Town & Country Planning Act 1990 (as amended)
Town & Country Planning (General Permitted Development) Order 2015 Schedule 2, Part 16

Application No: BE/55/20/TEL
Site Address: Land Off Rowan Way Bognor Regis PO22 9QQ
Description of works: Prior notification under Schedule 2, Part 16, Class 2 for erection of 17m mast with 6 No. antennas, equipment cabinets and ancillary development.

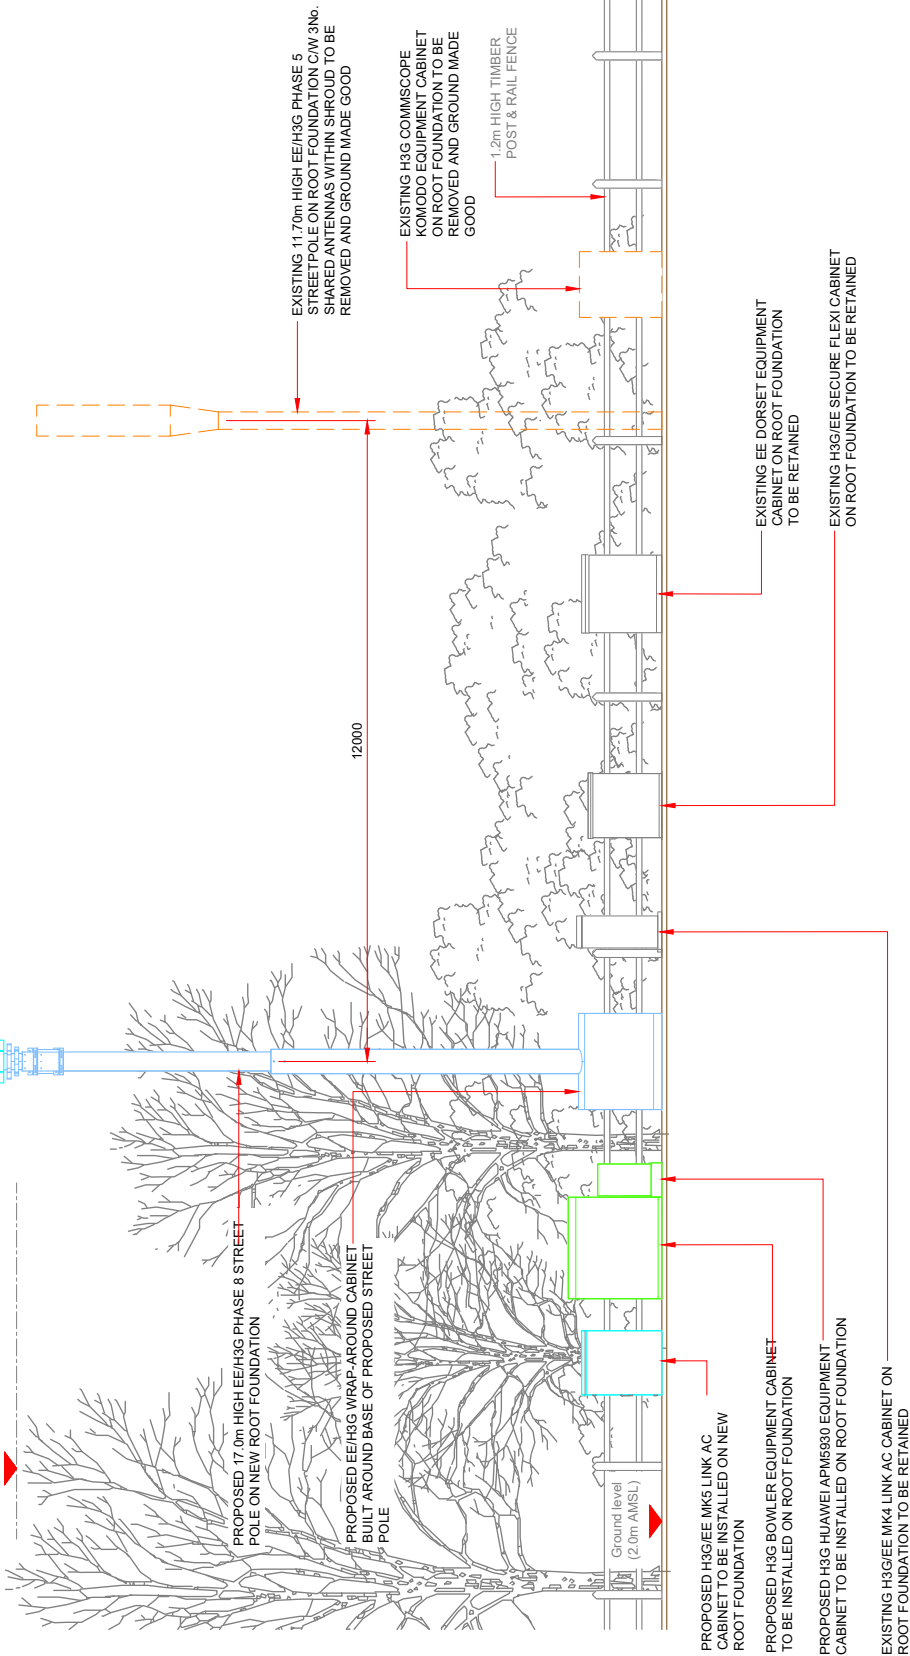
But would ask that the mast is coloured brown to blend in with the surroundings.
Also is the old equipment being taken out?
